PLANNING CONSULTATION RESPONSE

Application No	2026/0120
Proposal	Change of use from dwellinghouse (Use Class C3) to small HMO (Use Class C4).
Address	32 Dodworth Road, Barnsley, S70 6DY
Date of Consultation Reply	26.3.26
Consultee	Stacey Fieldsend-Case Management Officer

PROPOSED GROUND FLOOR PLAN

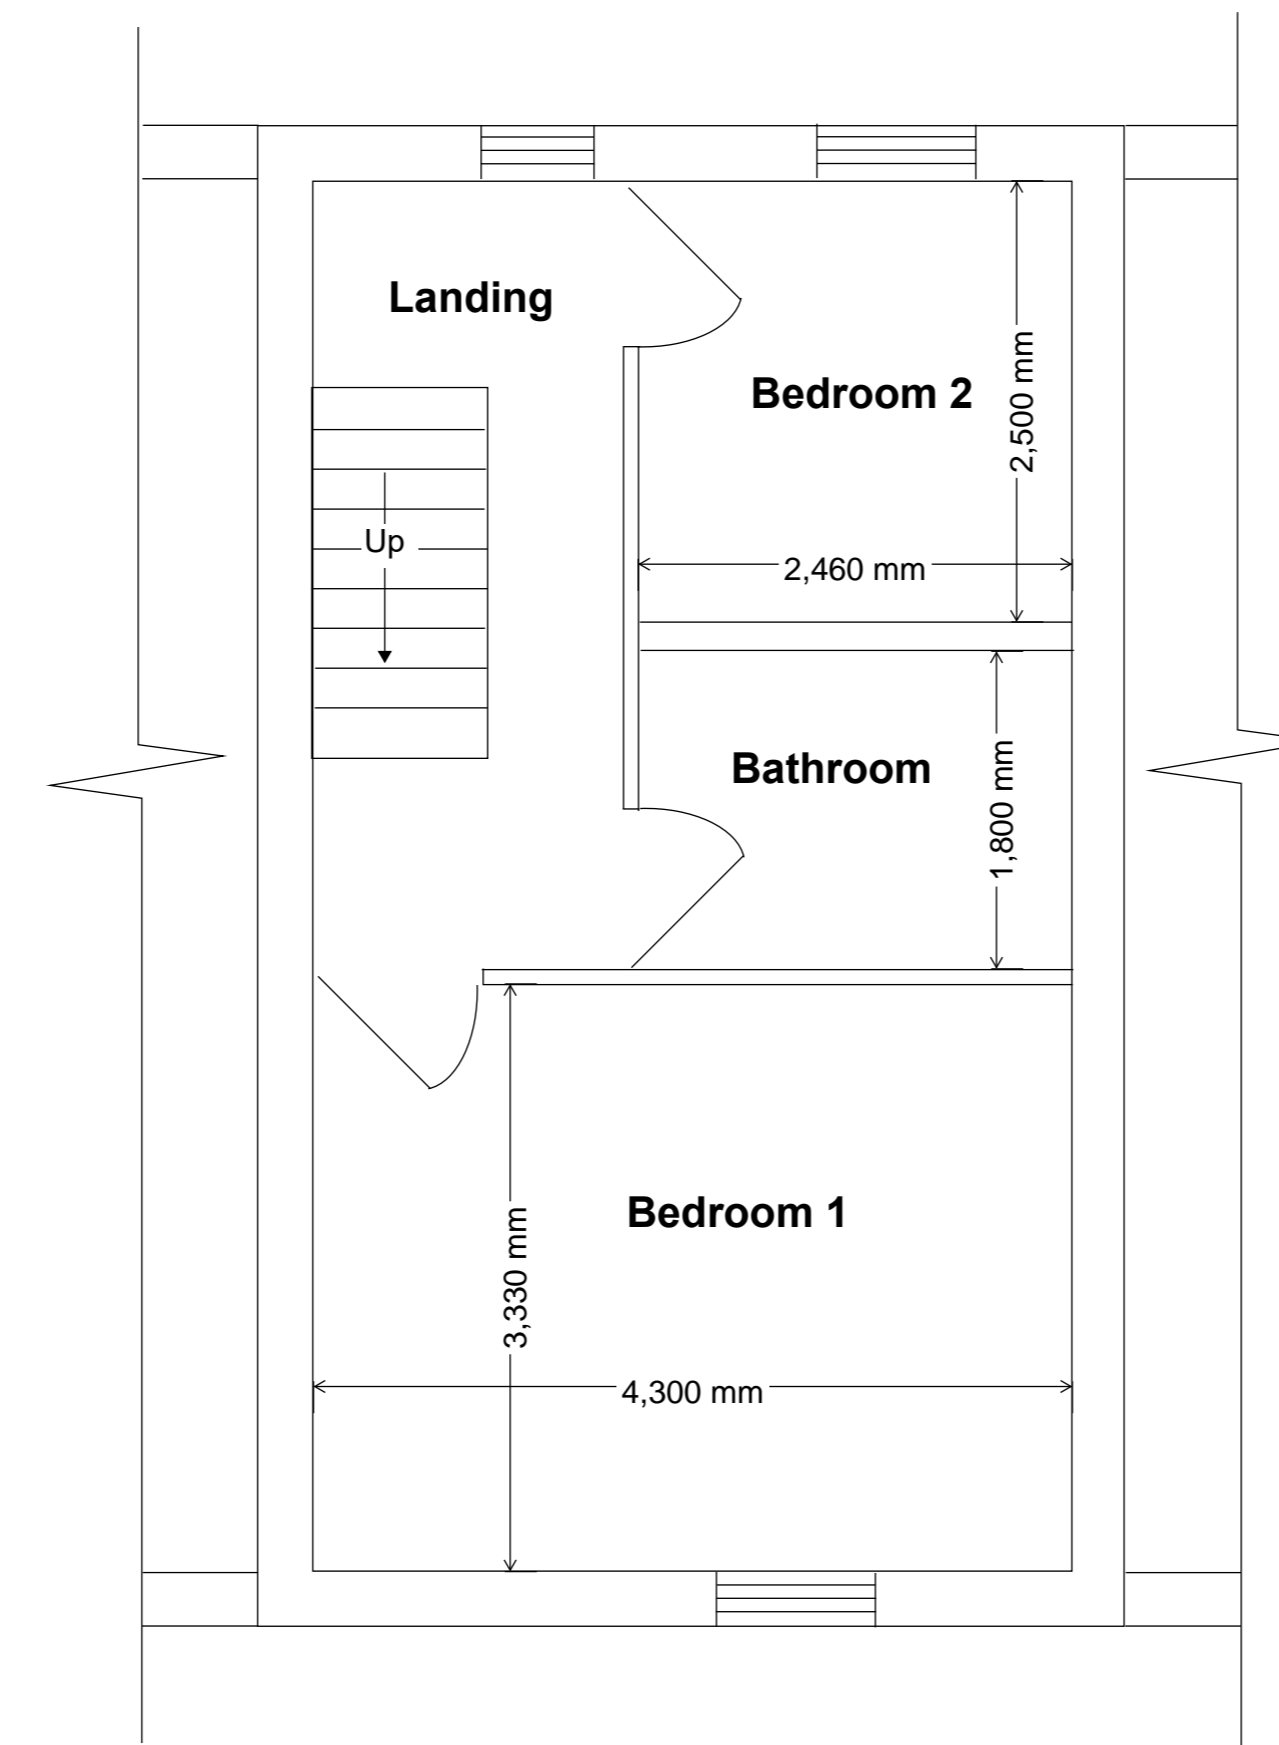
However, I inspected the property in January 2026, and the internal layout observed at that time did not reflect the plans currently submitted. Specifically, the ground floor front room was being used as a bedroom rather than as a living room. In addition, Room 2 did not meet the minimum bedroom size requirement of 6.51 square metres and was unoccupied at the time of inspection. The property owner was aware that this room was undersized.

- The ground floor front room is retained as a bedroom, with Room 2 repurposed and used as a small living room; or
- The ground floor front room is used as a living room, with the property occupied as a three-bedroom HMO, and Room 2 remaining unoccupied due to its insufficient size.

A living room must be provided and remain in use as one.

PROPOSED FIRST FLOOR PLAN

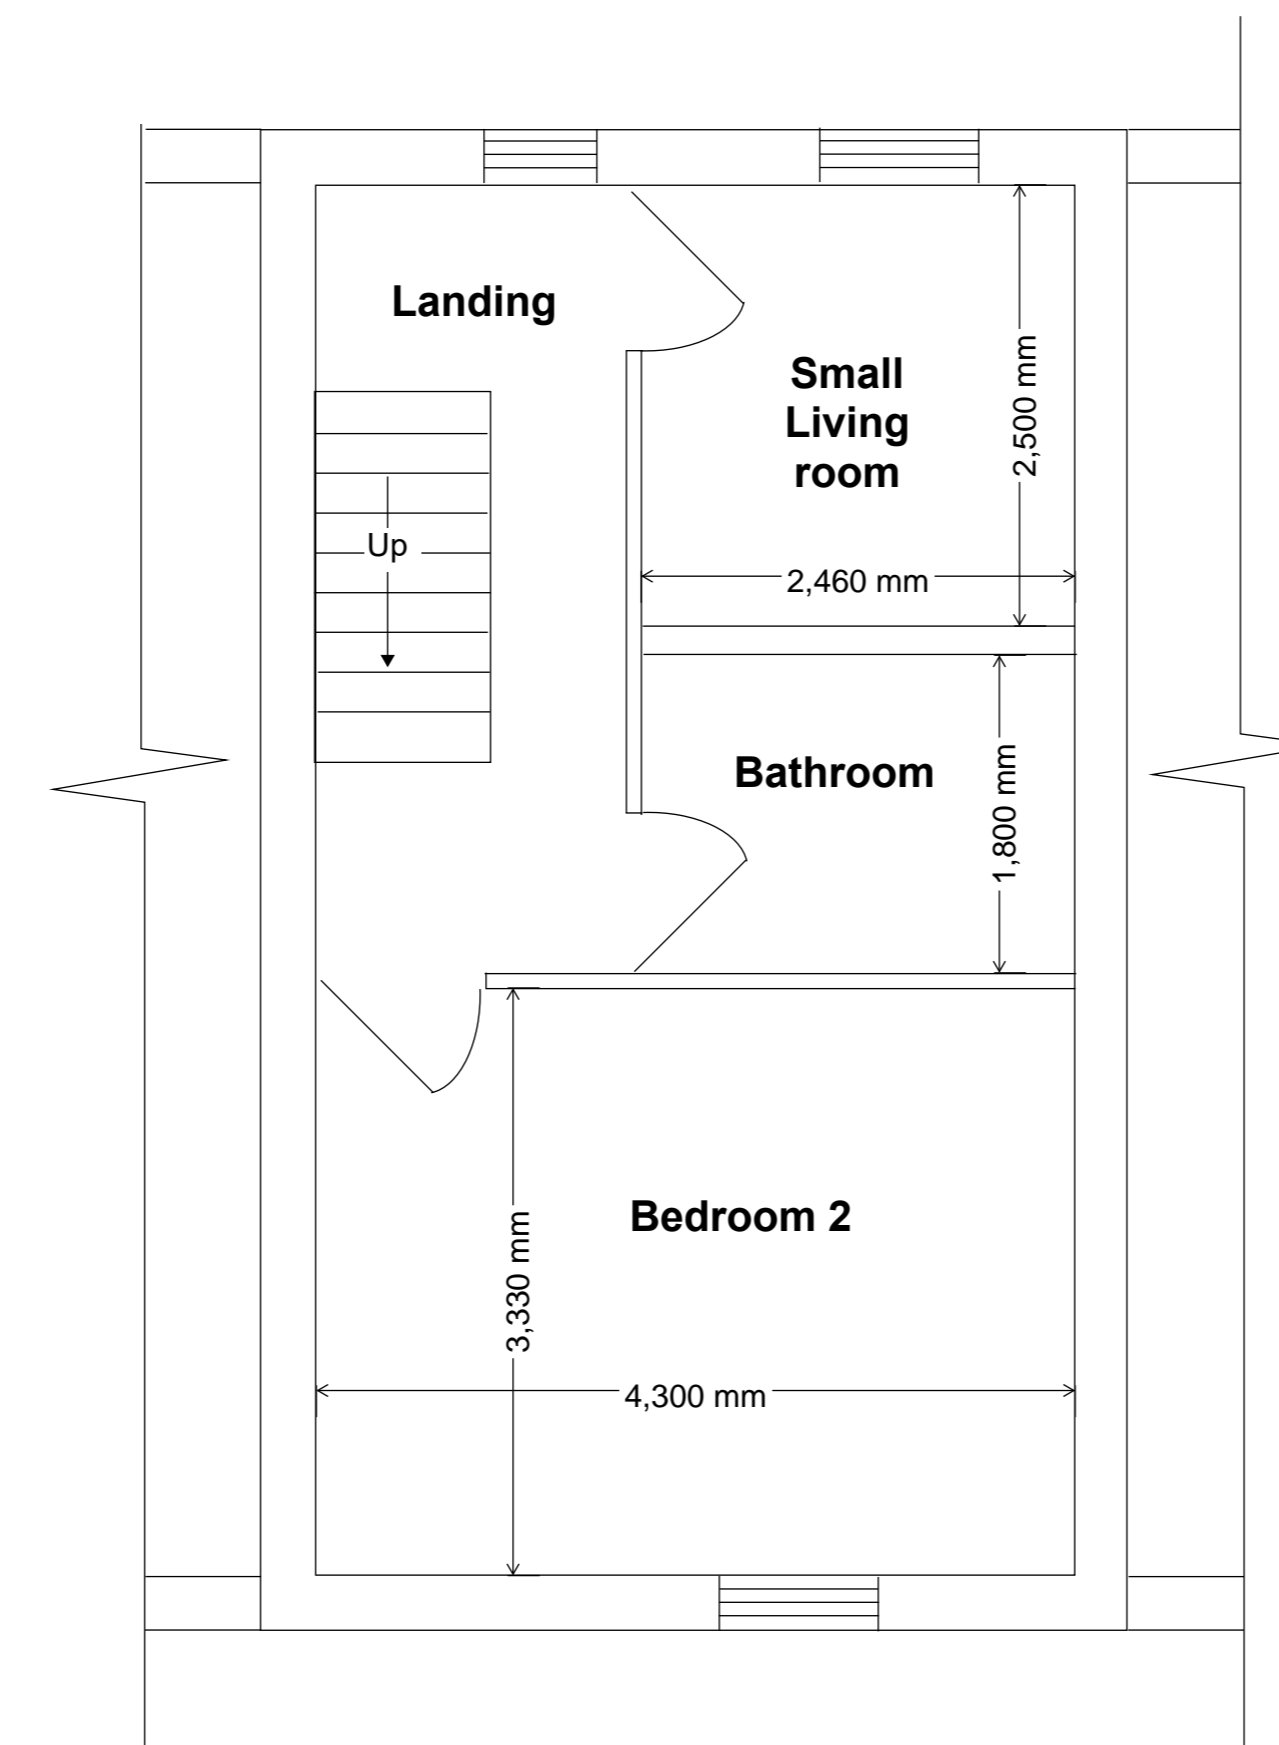
Clarification from the owner that Room 2 measurements are not as indicated on the drawings.
